7 November 2016

Re: [Smeaton Grange Waste Recycling and Transfer Facility Response to Submissions Report \(SSD 7424\)](#)

FOR DA APPROVAL			
J15306	DA	100	D
job no.		drawing no.	rev

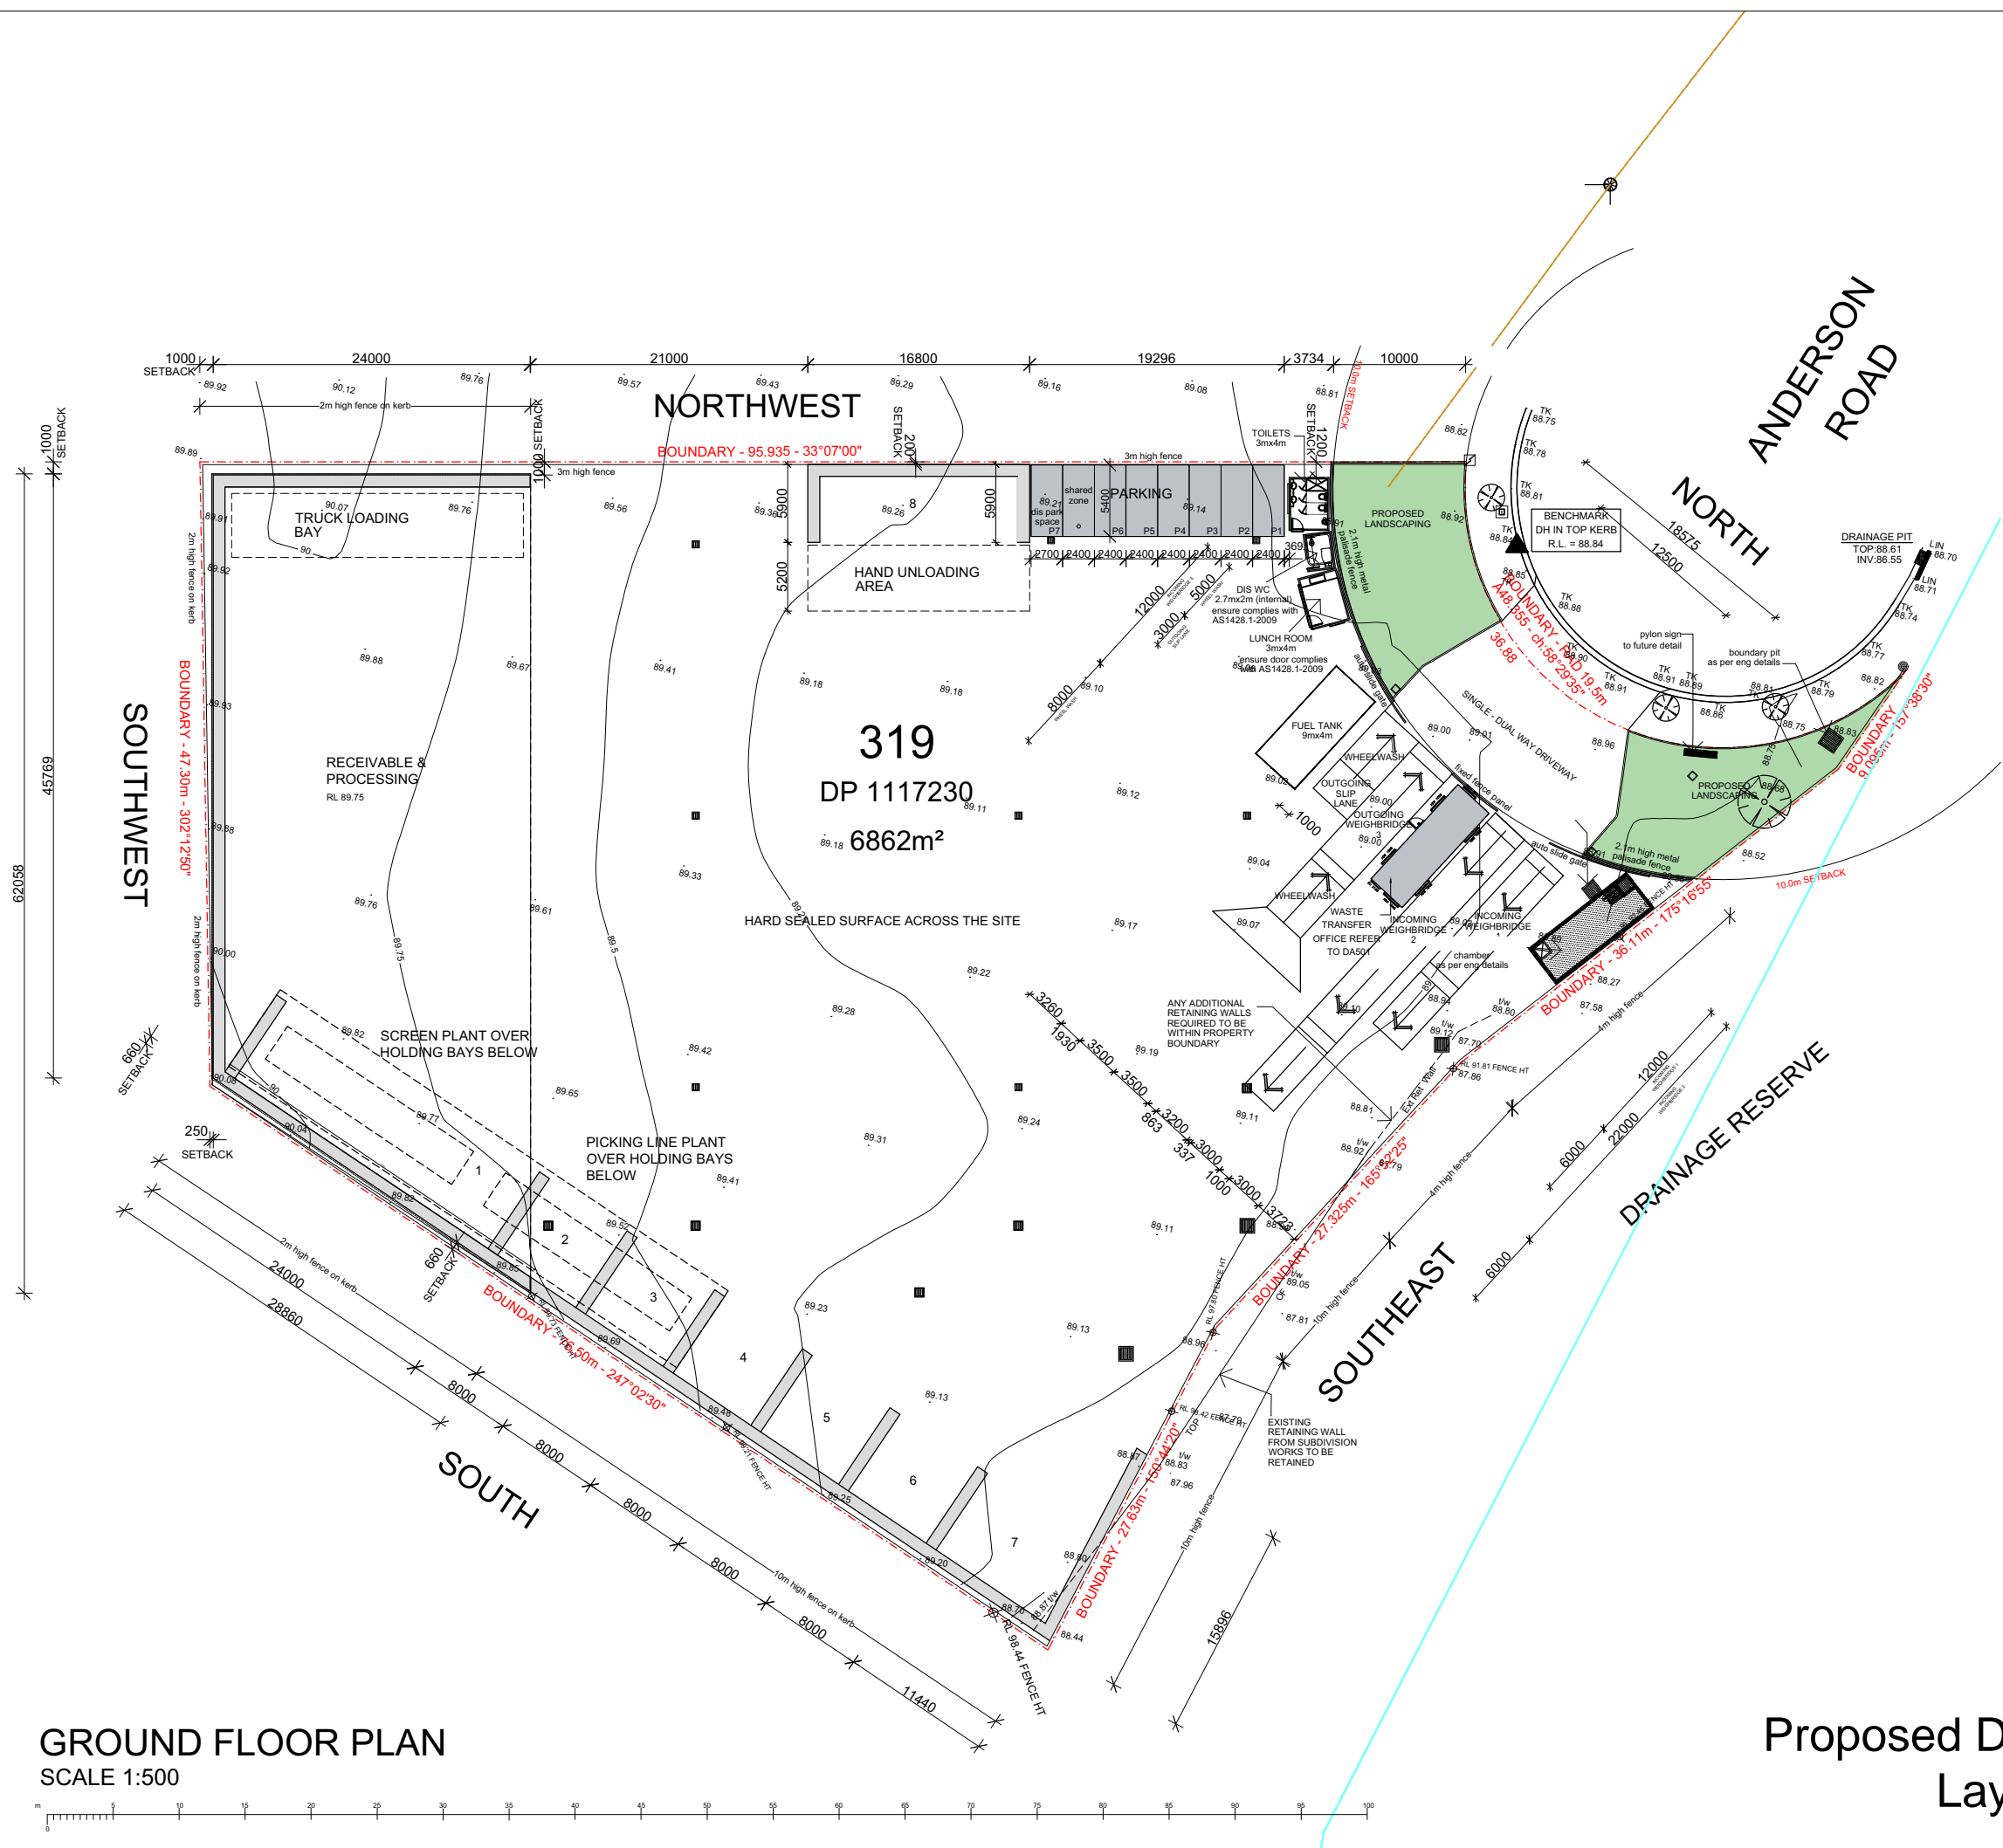
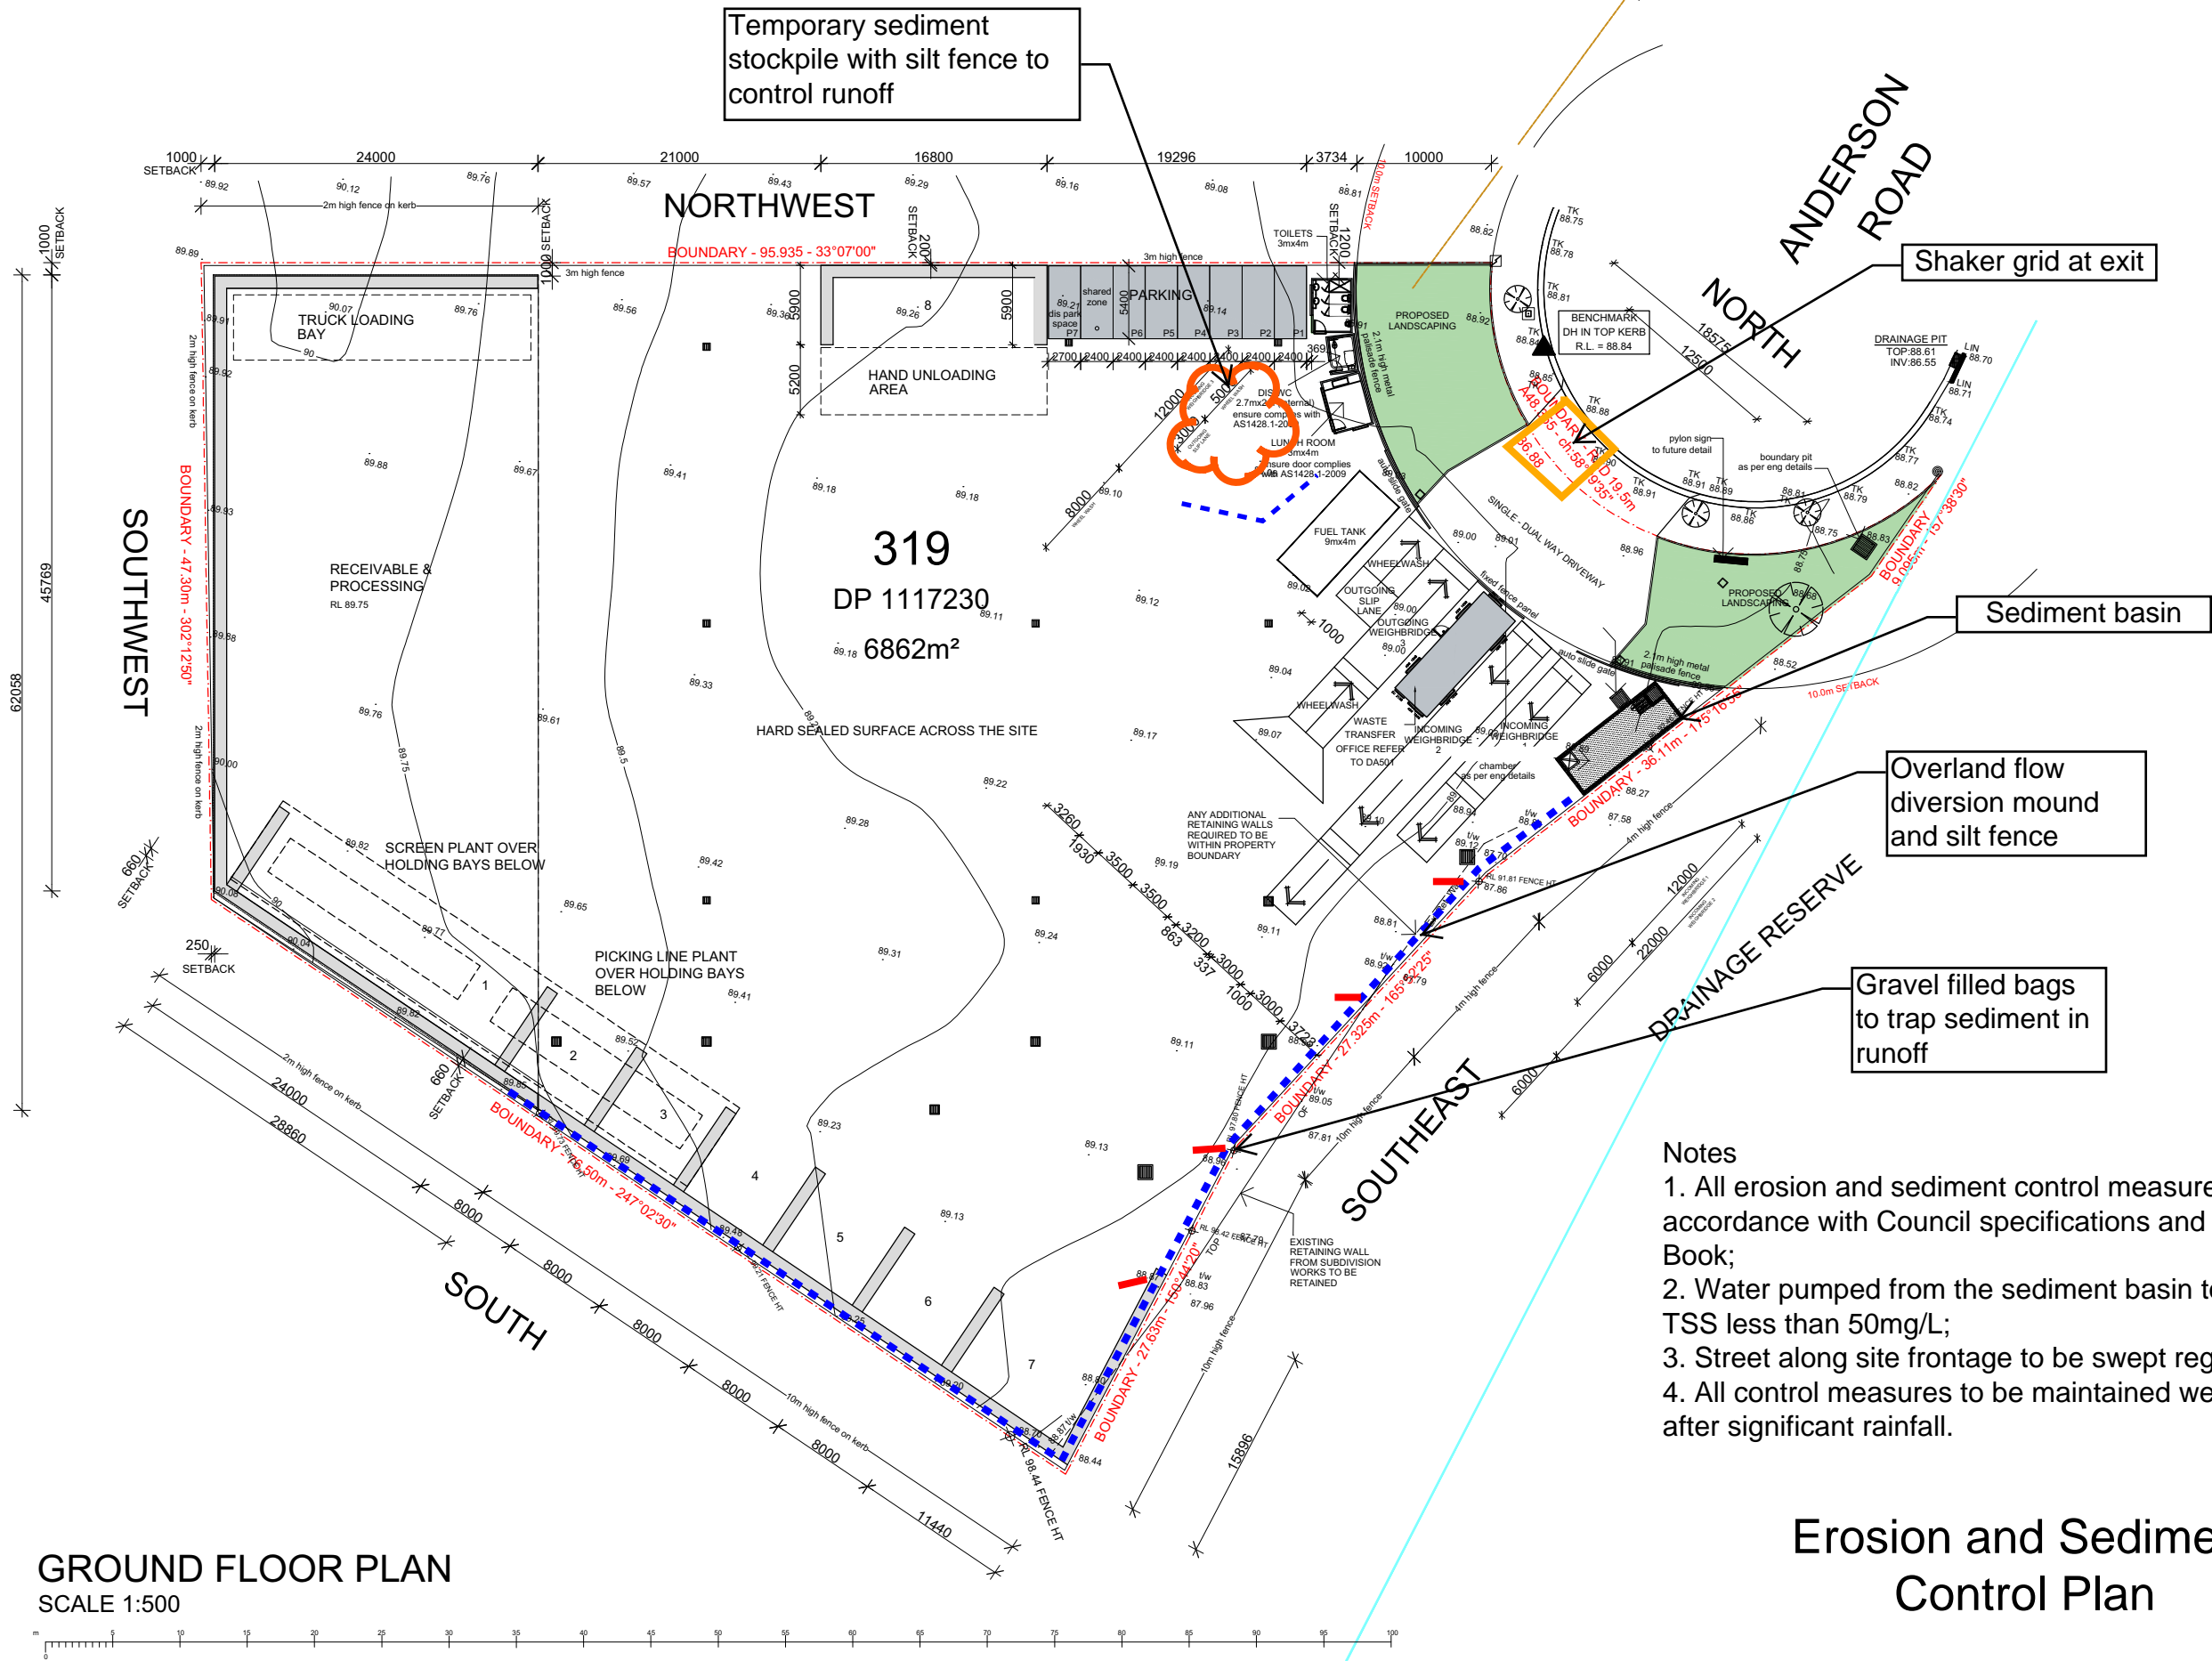
3.2.1.	Noise – ii sleep disturbance	Include measures to mitigate for sleep disturbance or at least reference management measures to minimize impacts.	Additional information is provided in Section 3.2.1
Figure 3.3.	Site Plan	Show on Site Plan Figure 3.3 it would be useful to label storage bays on site plan. Also Indicate storage site for green waste and residual waste for landfill. Indicate where in the shed that bulk light waste and ferrous and non-ferrous metals and green waste would be stored.	The site plan has been updated accordingly.

3.7.5.	vii Overnight bin storage	Provide designated bin storage given that vehicles start arriving at 6am and would need clearances for manoeuvring around on site.	The site plan (Figure 3.3 updated to include a bin storage area and the Section 3.7.5vii amended accordingly.
